Your Ref: OWPC25088
Our Ref: FG/127/19/HH 22-10-2019
Please ask for:
Finlay Gardner

Loft conversion & reconfiguration of South elevation
11 Ferring Marine Ferring

Thank you for your internet representation made on 26th November 2019 which has been recorded as '**no objection**' with the comments as follows:

PROPOSED  
ELEVATIONS AND  
MAIN SECTION

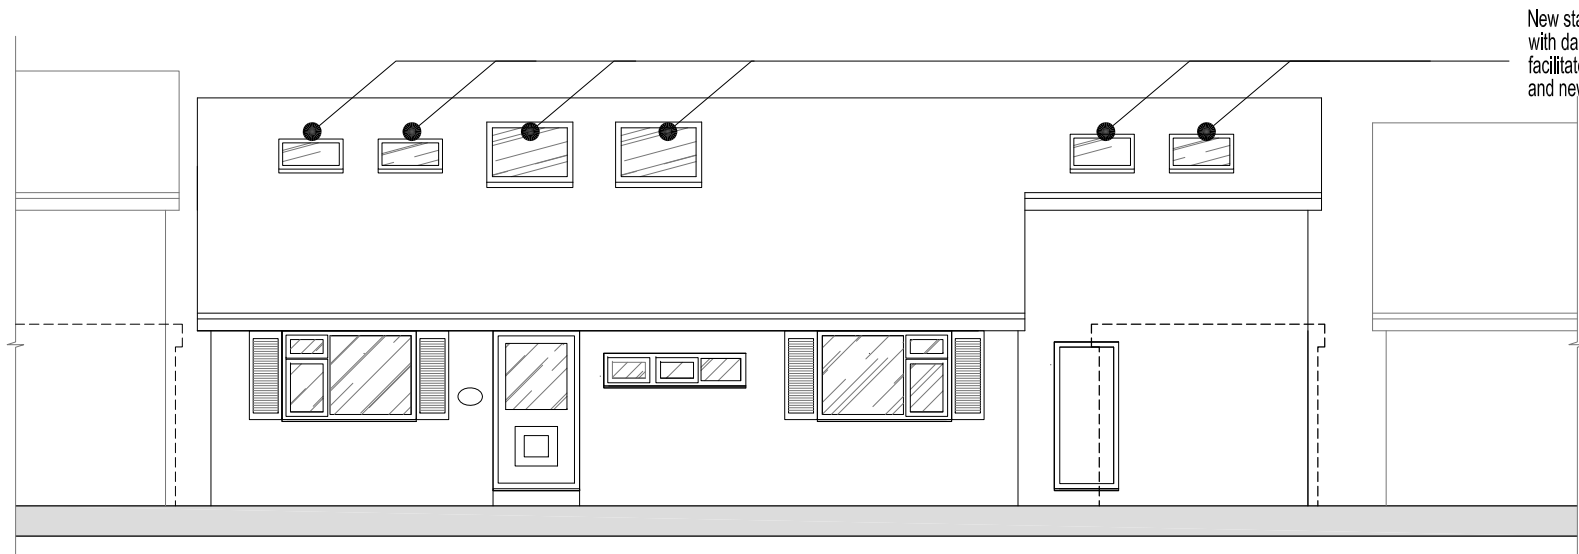
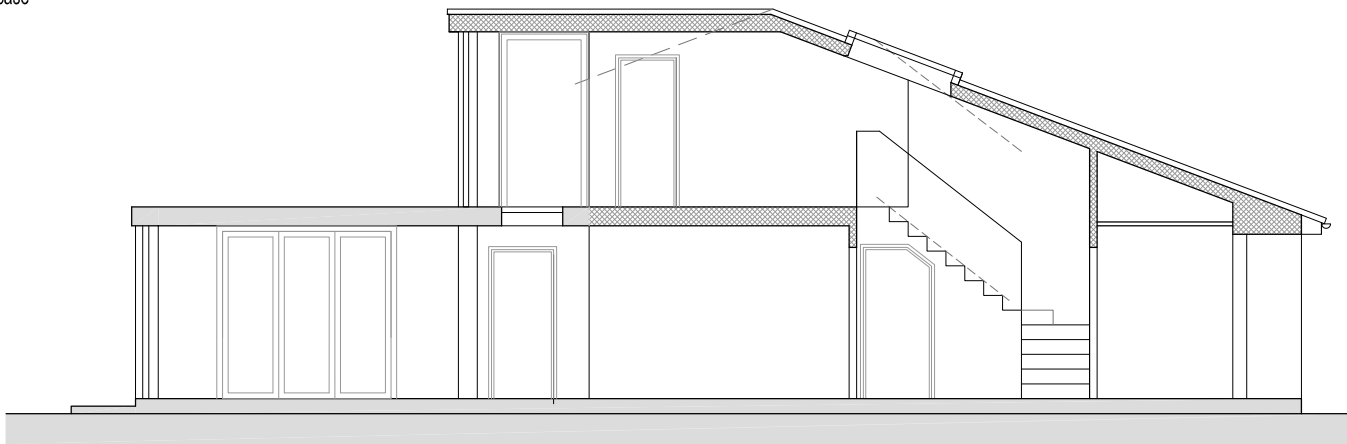
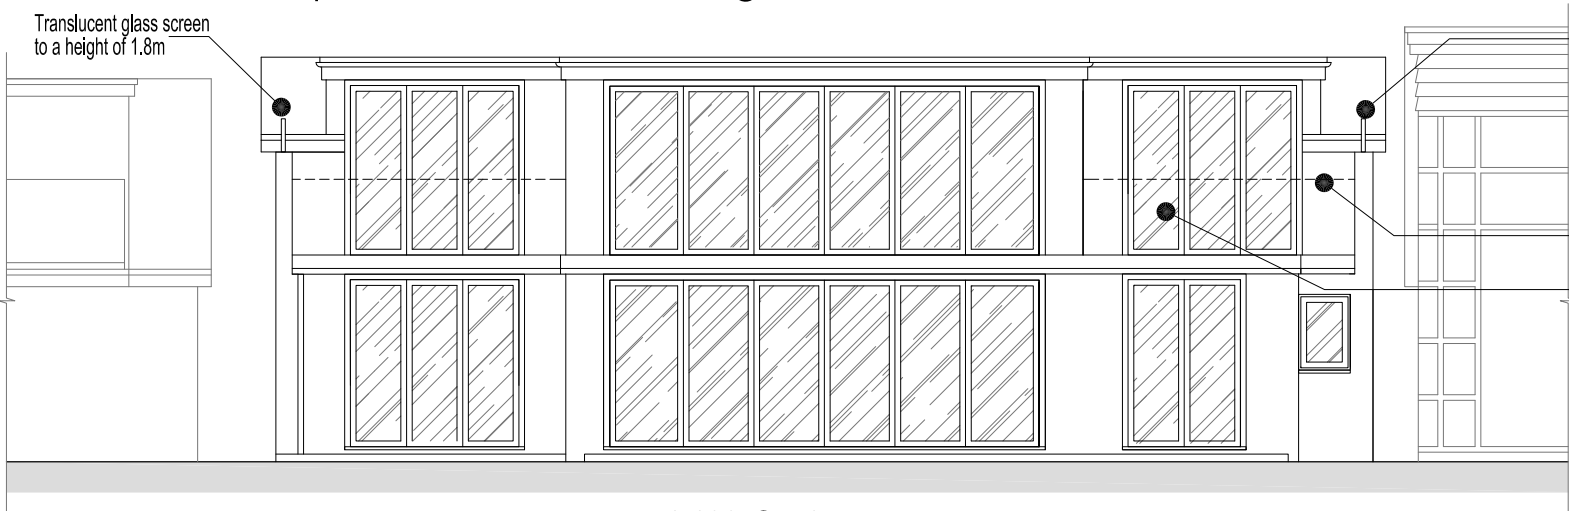
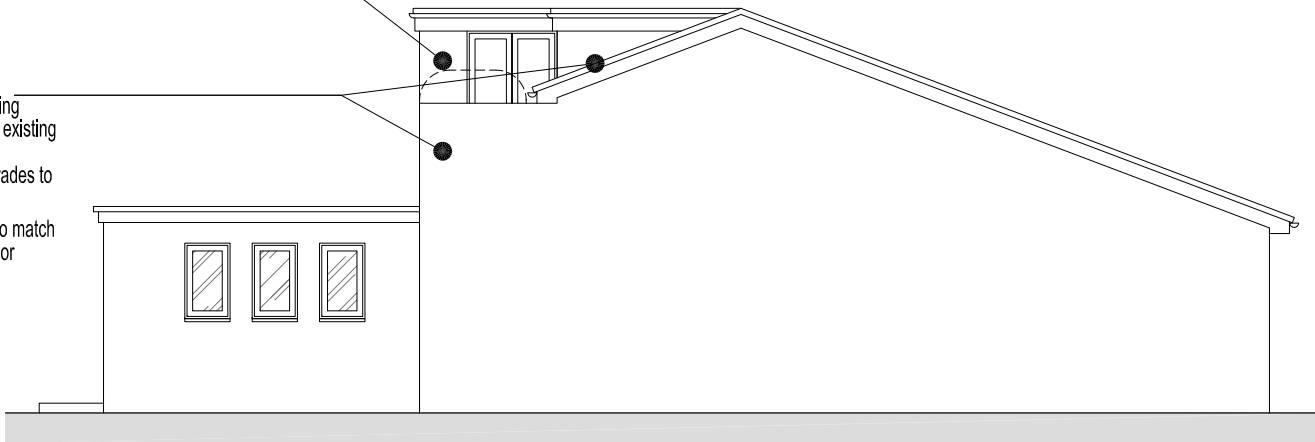
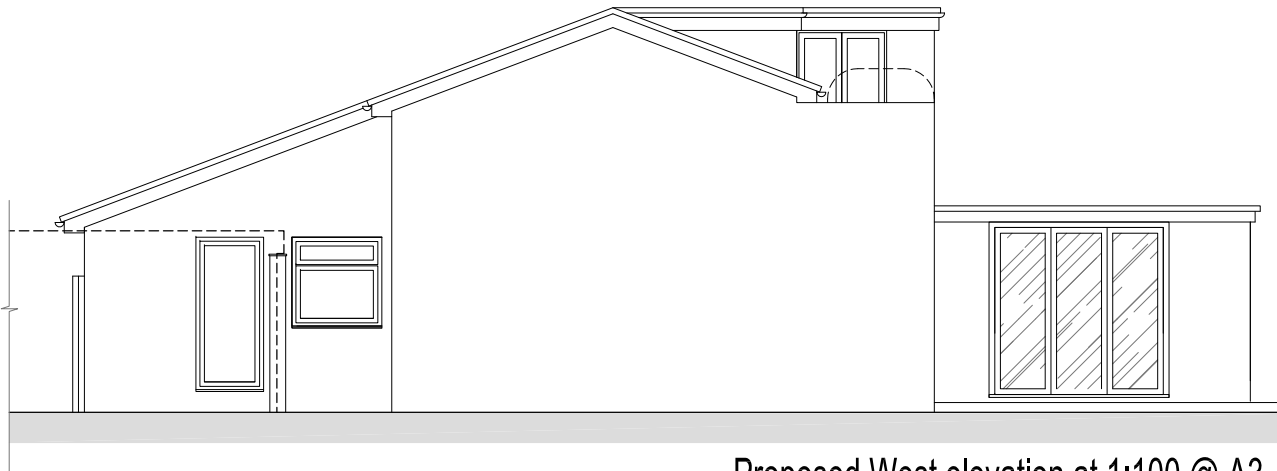
I have however been assured by the owner that the glass in the 3 windows will be obscure which I suppose helps a bit if they are fixed and can be opened.

We do not object to the proposed loft extension as we have historically created a similar space but we are a little confused, the main sliding doors from the upstairs lounge that open out onto the green roof have nothing stopping access out onto the roof and it could be used as an additional terrace. We have seen Juliet balconies with glass panels which would not prevent the enjoyment of the view but would prevent access out onto the roof to be used as a terrace which would impact our privacy immensely.

The row of bungalows are all in line and the proposed parapet wall with glass screen on the eastern elevation would also look quite harsh, even though symmetrical, I accept that changes and alterations do occur but when we extended our own house we spend a lot of time and effort designing a double storey glass corner wall to maximise the Westery sun and views and now that side of the house not only has to look over a 6x8x3 meter extension that used to be mature trees and hedges and now a brick wall on the first floor to enclose a small balcony. I am aware that loss of view is not a reason to deny an application so would suggest a obscure glass screen on that side rather than a wall if needs be. When we built our extension were sympathetic to our neighbours and we left a large gap to our adjoining neighbours to prevent the overbearing bulk of building along the boundary/party wall to both sides.
